SUBJECT: Engineering Review Comment  
Mountain View Electric Association Inc. (MVEA)

**Project Name: 11060 Fontaine Blvd Grand Mountain PPR Amendment**

**Project Number: PPR2611**

**Description:** Proposed addition of modular building located at 11060 Fontaine Blvd in Township 15S, Range 65W, Section 13.

SHEET NAME
ENLARGED SITE PLAN
SHEET 2 OF 7

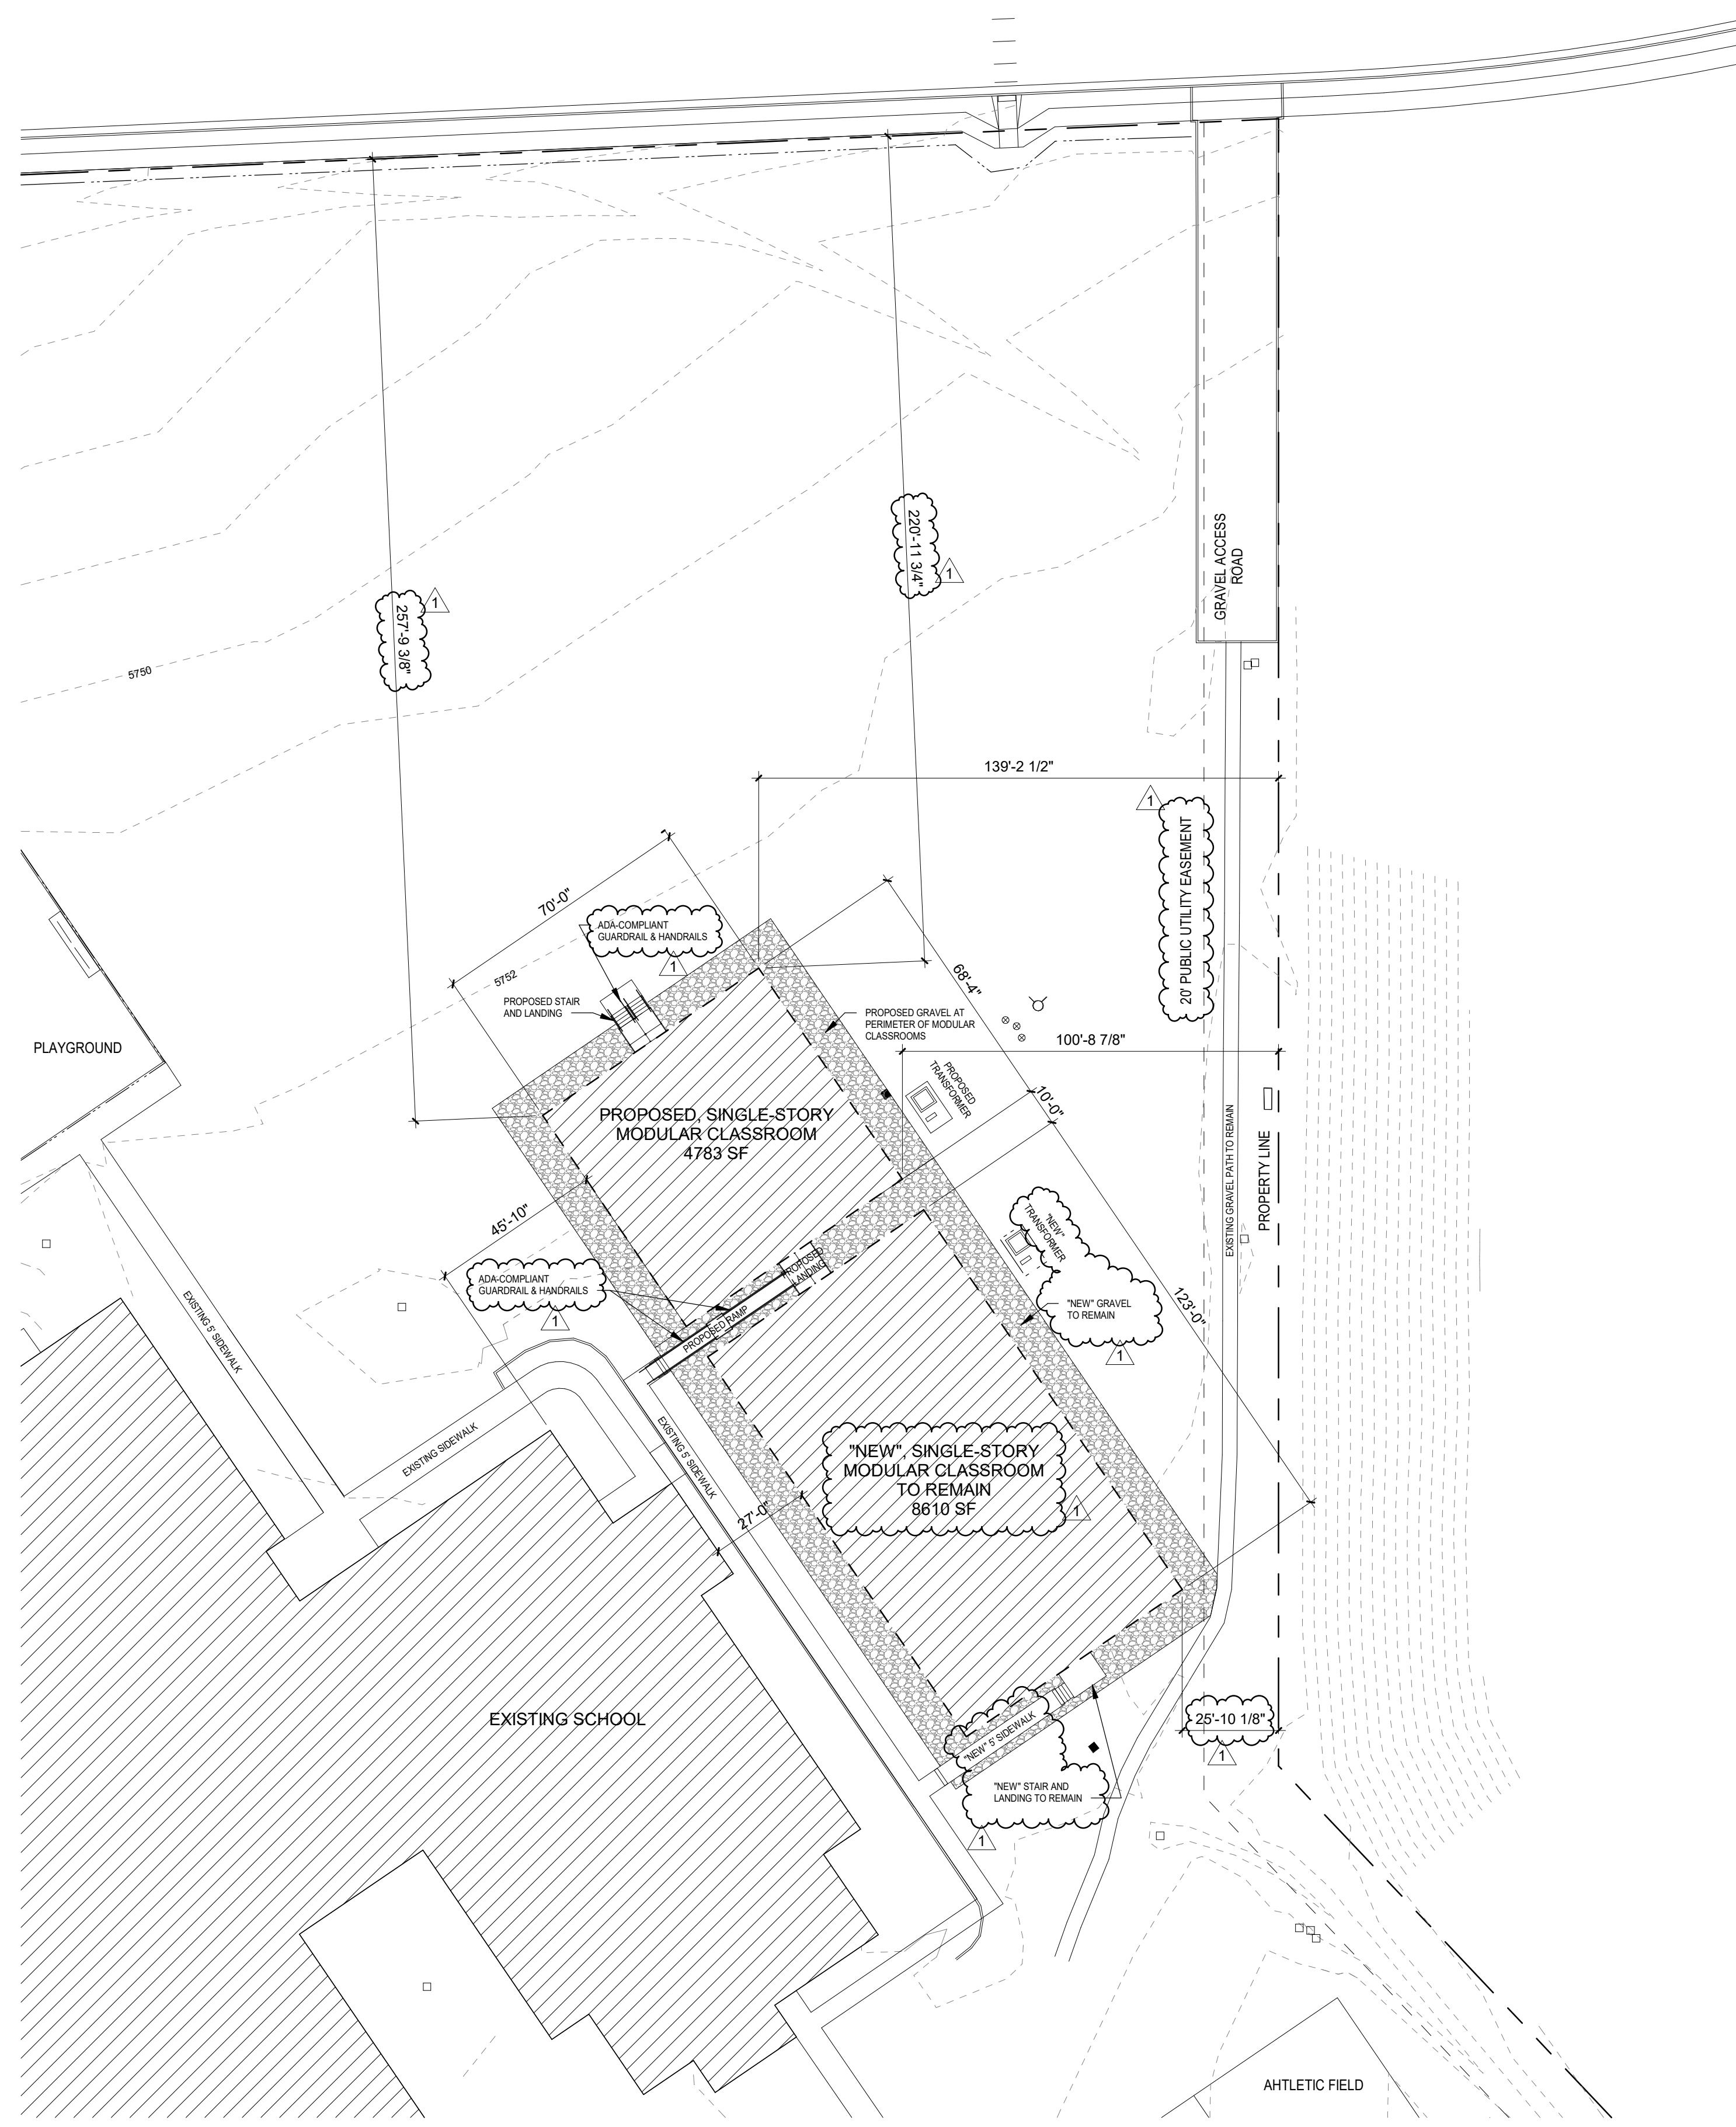
MVEA does not agree with the proposed location of the modular building addition because it conflicts with existing electric facilities located within an established easement and would block required access to MVEA's underground facilities for future repairs or maintenance. If there is any damage, removal or relocation of facilities it will be at the expense of the applicant.

MVEA will work with the developer on the design of the electric service and to acquire any needed utility easements. MVEA also requests the platting of MVEA's existing facilities with easements on the plat.
